DRB Application No.: 05DRB-01828 *(P&F)*

Project # 1004570

Project Name: NORTH ALBUQ. ACRES, UNIT B

# DRB CASE ACTION LOG (PREL & FINAL)

Plat of
 Lots 6-A-1 and 6-A-2, Block 14
 Tract A, Unit B
North Albuquerque Acres
 Albuquerque, Bernalillo County, New Mexico
 November 2005

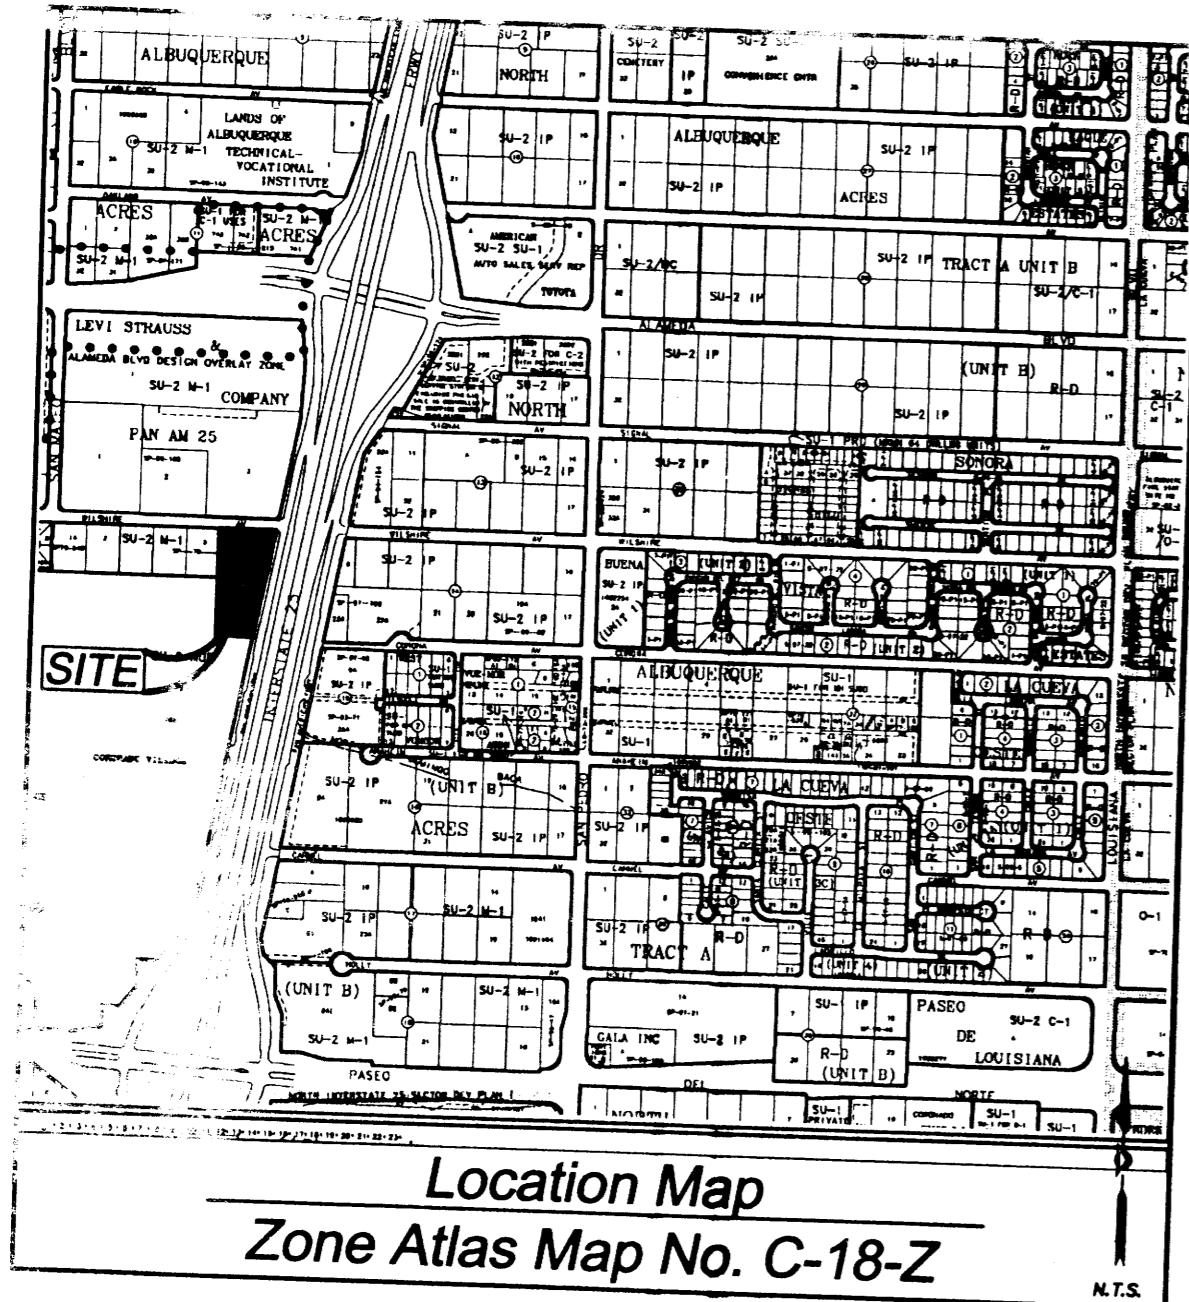
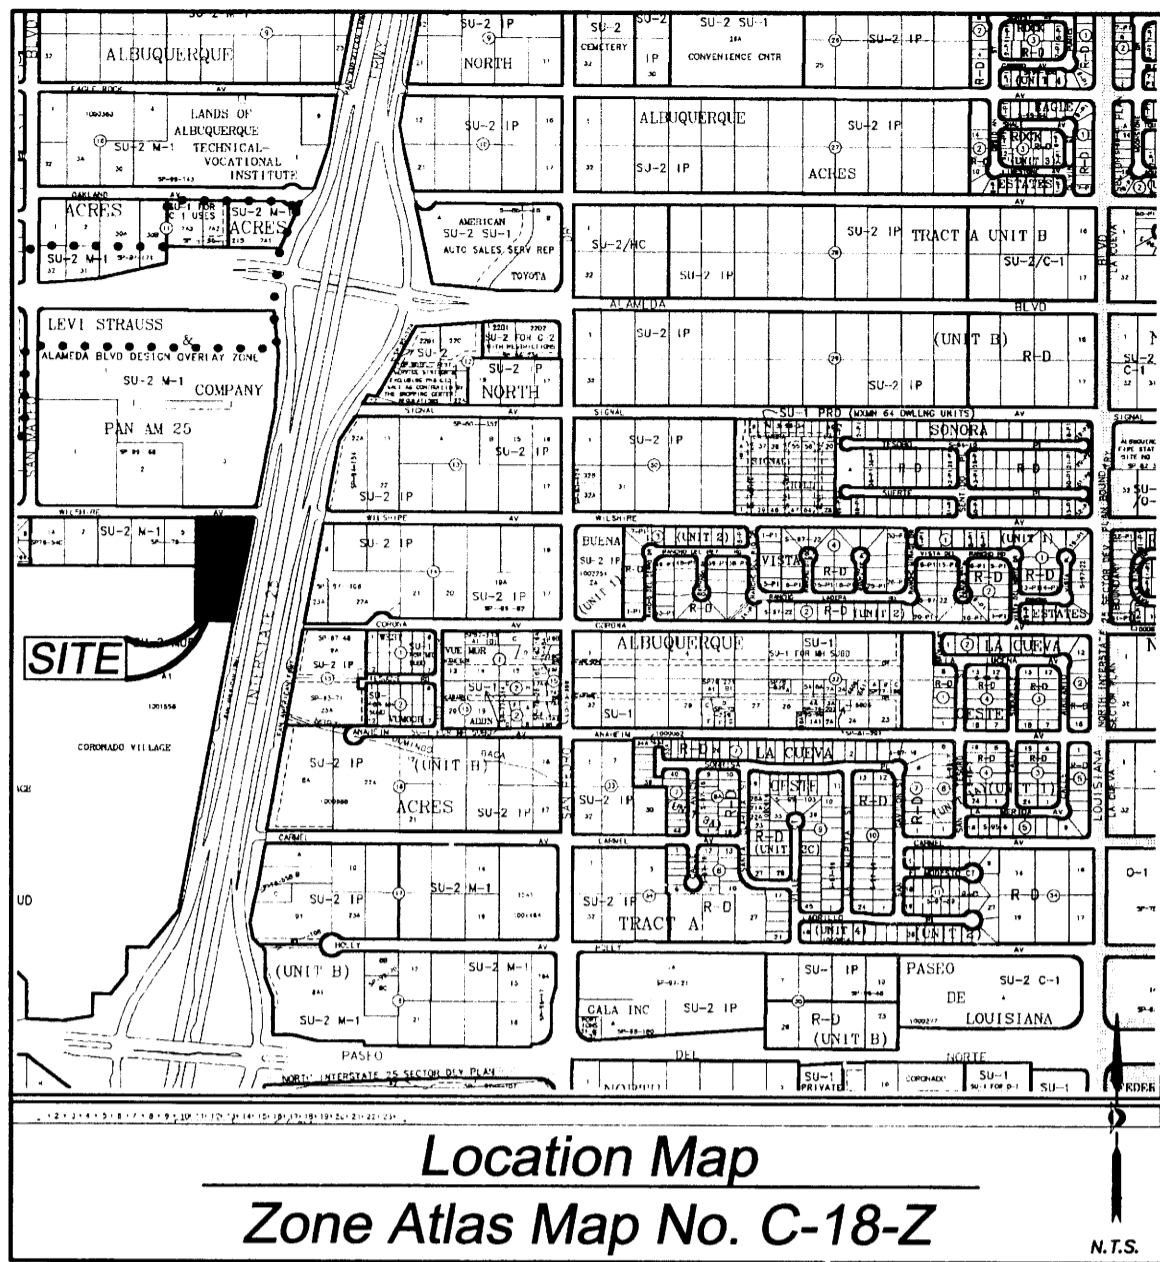
- UTILITIES: *add 15' private water (SAS source line easement for benefit of lot 6-A-2.*
- \_\_\_\_\_
- \_\_\_\_\_

AMAFCA must sign plat.

AGIS dxf is not approved.
